KIRKLEES METROPOLITAN COUNCIL INVESTMENT & REGENERATION SERVICE

DELEGATED DECISION TO DETERMINE PLANNING APPLICATIONS

Reference No:	2023/62/92461/E
Site Address:	Four Winds, 2, Highbridge Lane, Skelmanthorpe, Huddersfield, HD8 9JY
Description:	Erection of extension and alterations
Recommending Officer:	Elenya Jackson

DECISION – REFUSE

title General Arrangement as Existing
number 22014D-01-P01
scale 1:100
size A1

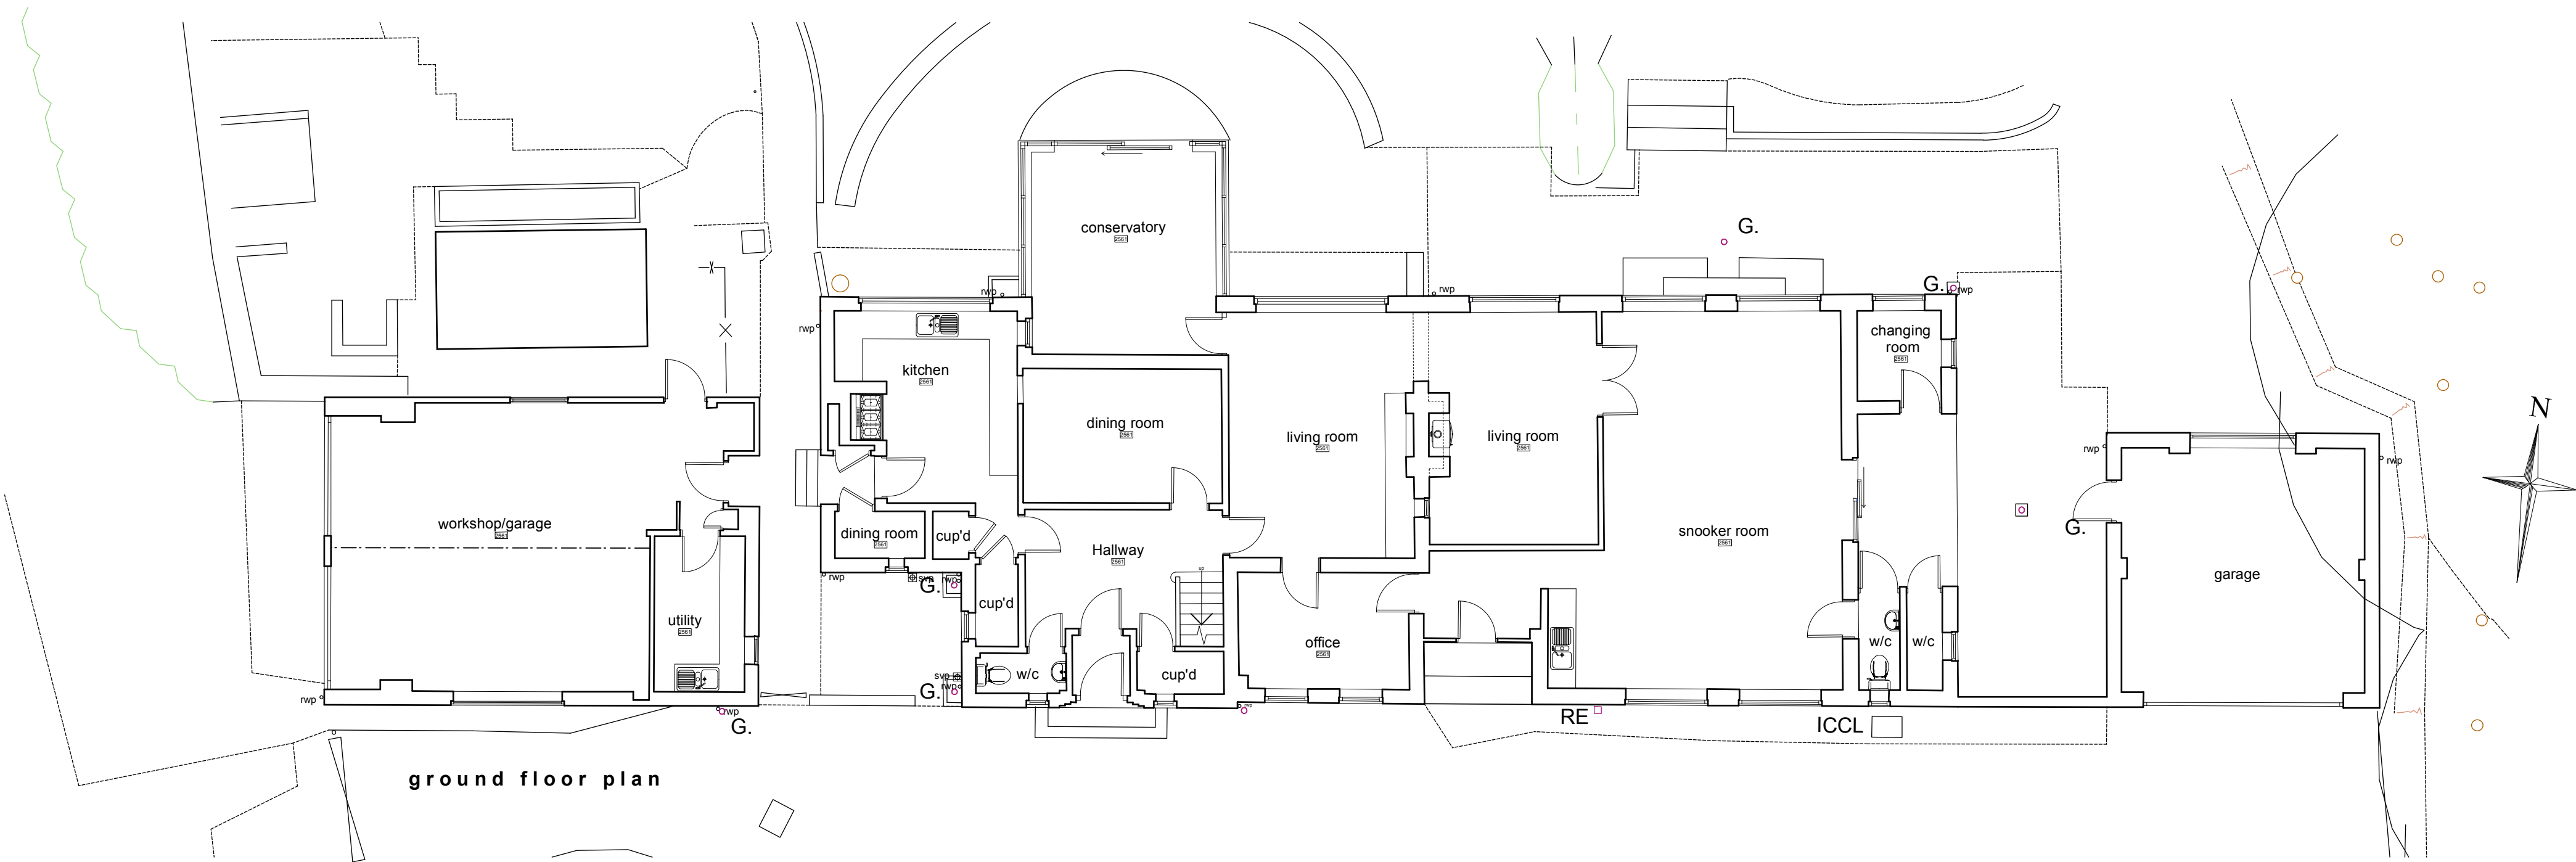
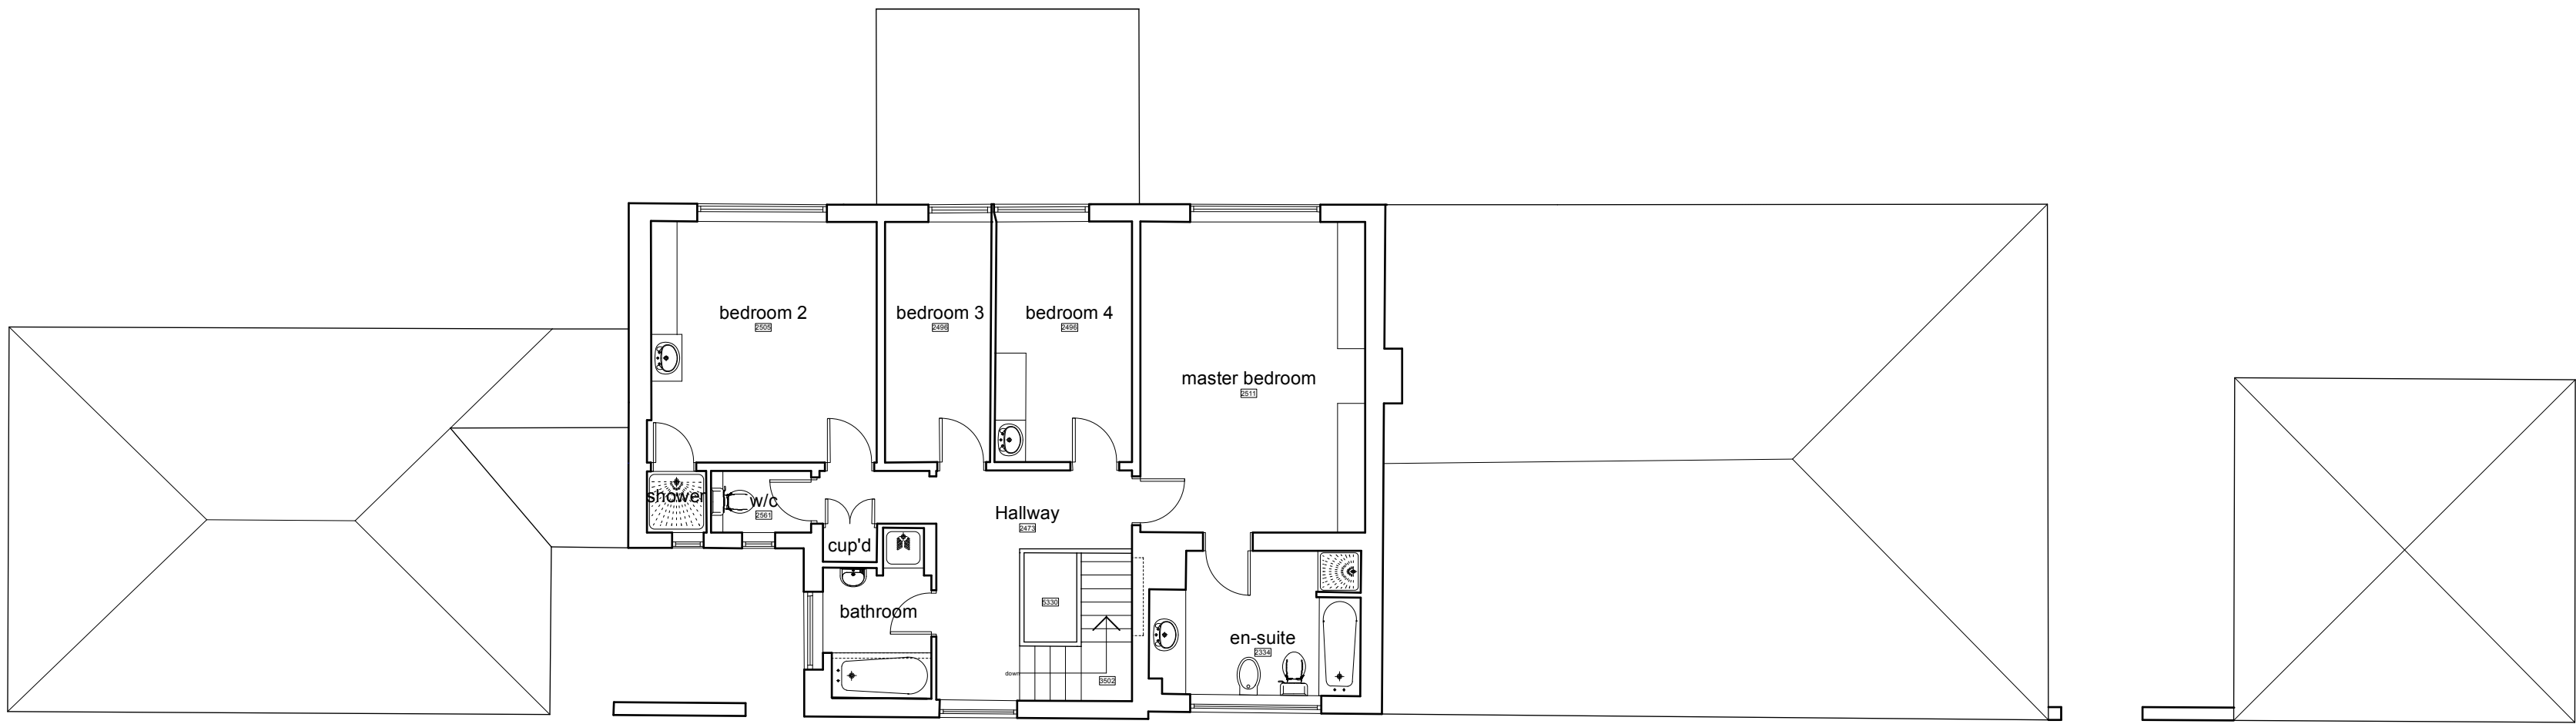
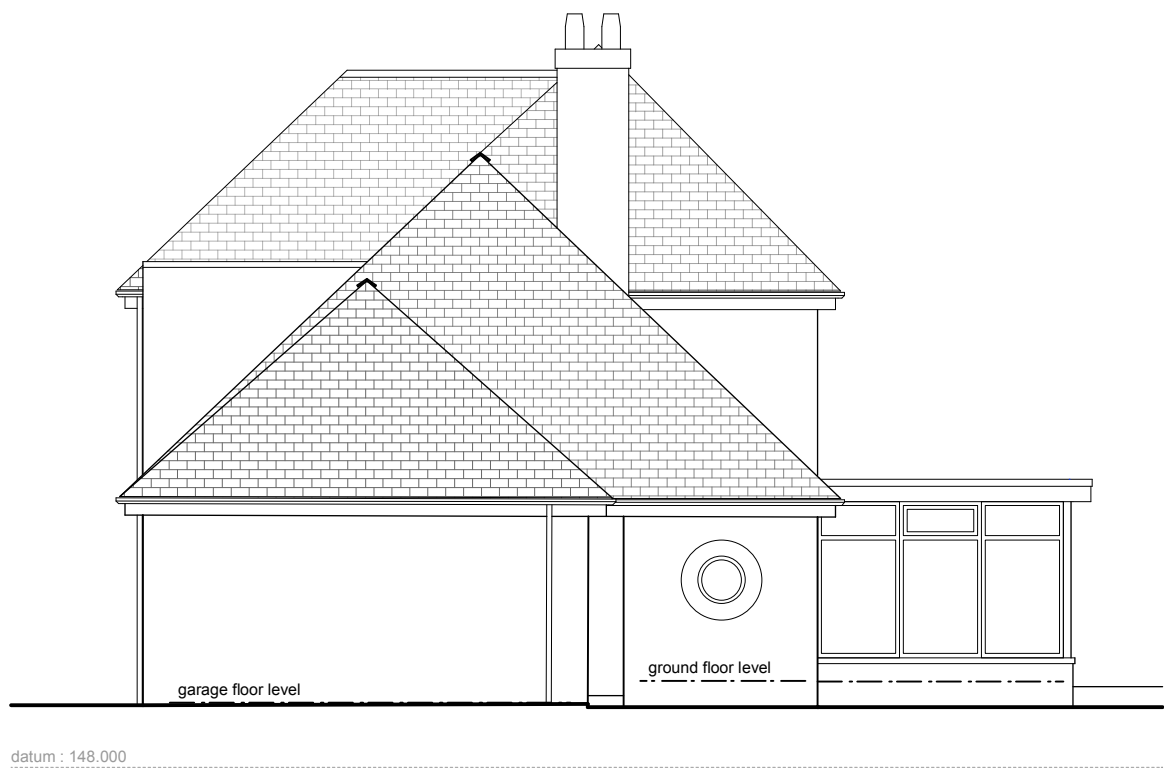
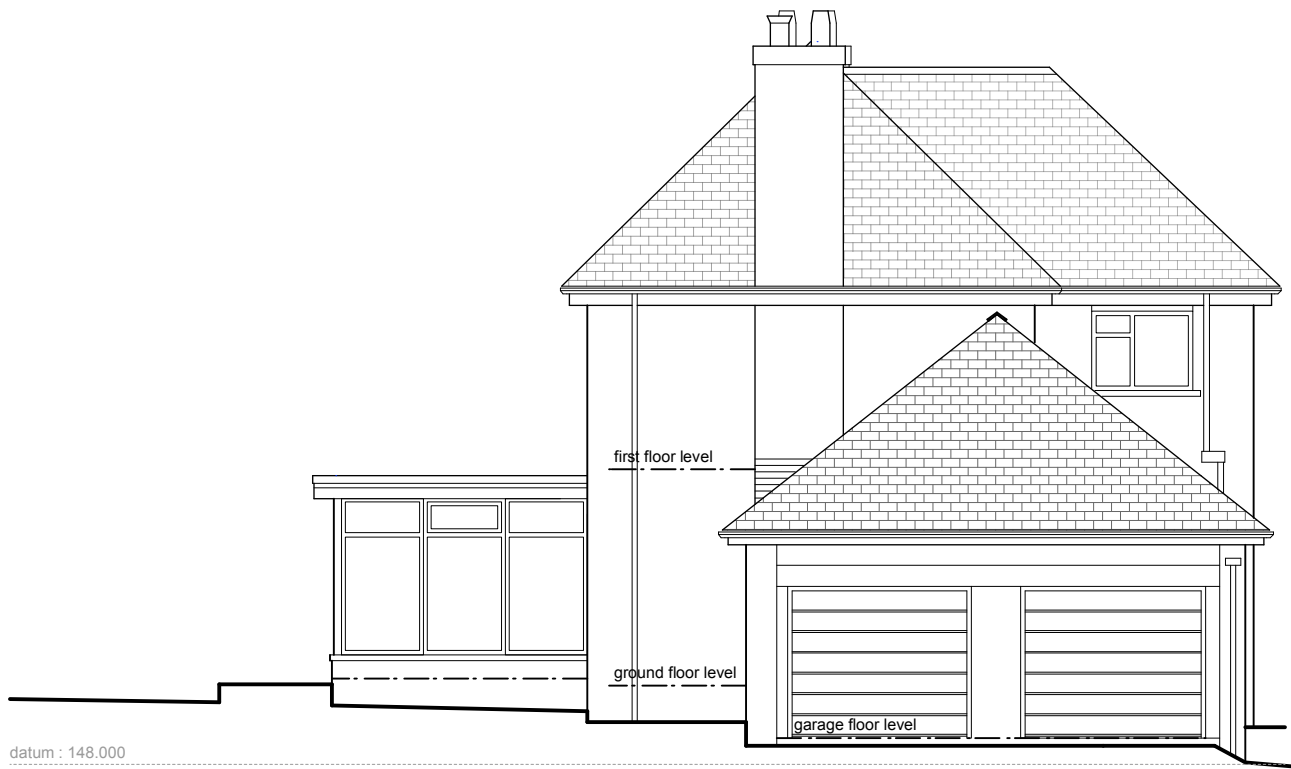
From the plans provided the ground floor footprint of the existing dwelling is approximately 321m² at ground floor level. From the approved planning history of the site, officers have been able to locate approximately 244.2m² of development.

On site, there is a rear conservatory and a workshop which officers have been unable to locate a permission for which have a cumulative floor space of 77m².

Without the addition of the current proposals, the development on site represents 186.6% increase in footprint to the original dwelling.
